Subject: RE: BN/50/18/PL The Fallows

Drainage advice received today in response to your email is that:

Standard Detail
High Storage Soakaway

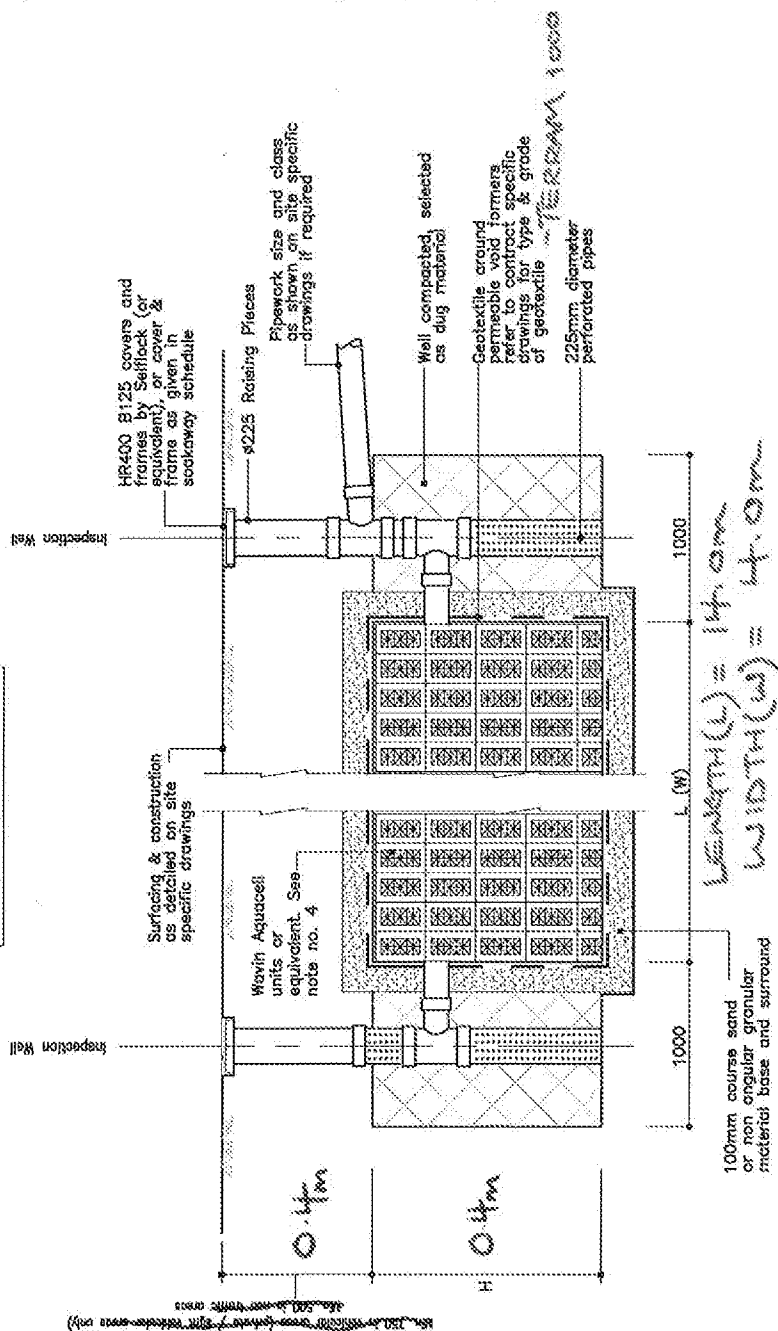
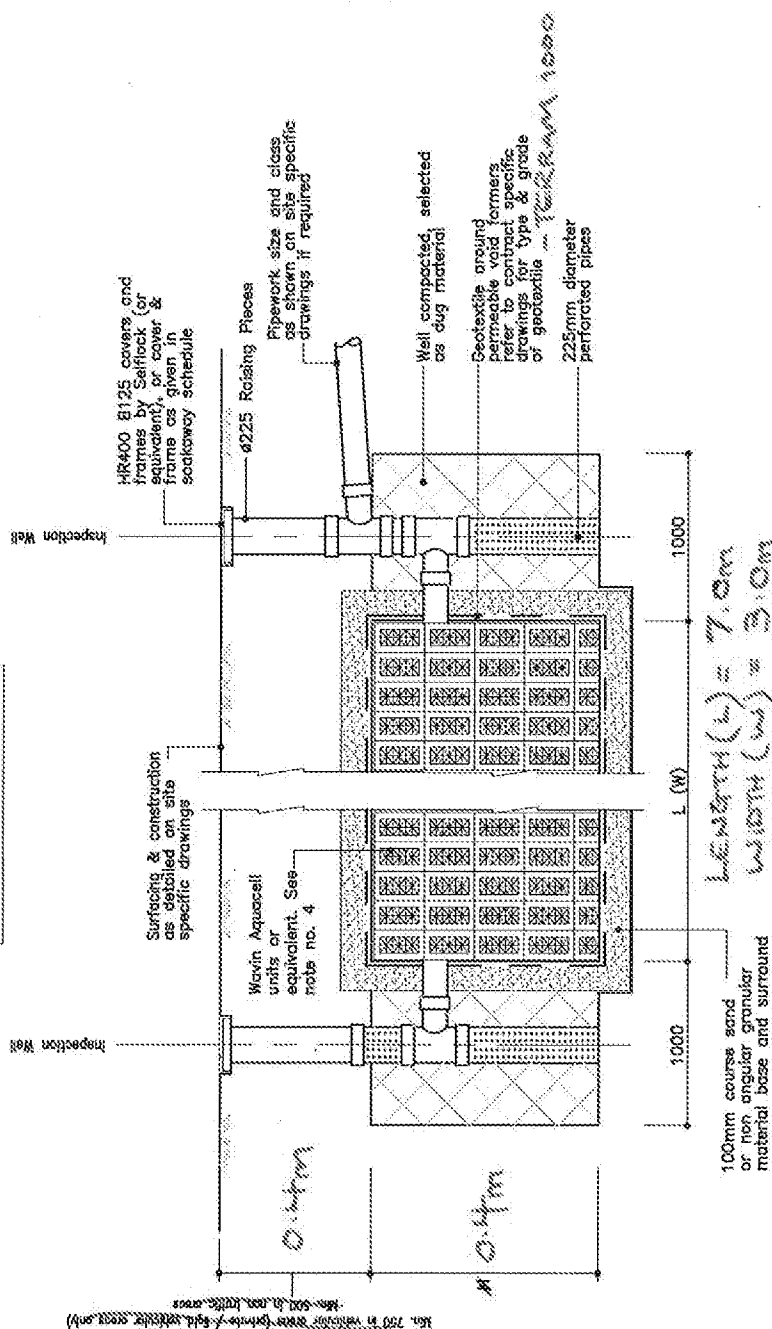
“It is unclear if the crates proposed would be suitable for such shallow cover depths. Furthermore, as detailed on the soakaway detail plans 100mm sand is required above the crates, this leaves only 100mm topsoil which wouldn't be sufficient to support grass growth. Shallower crates are available and should be looked at.
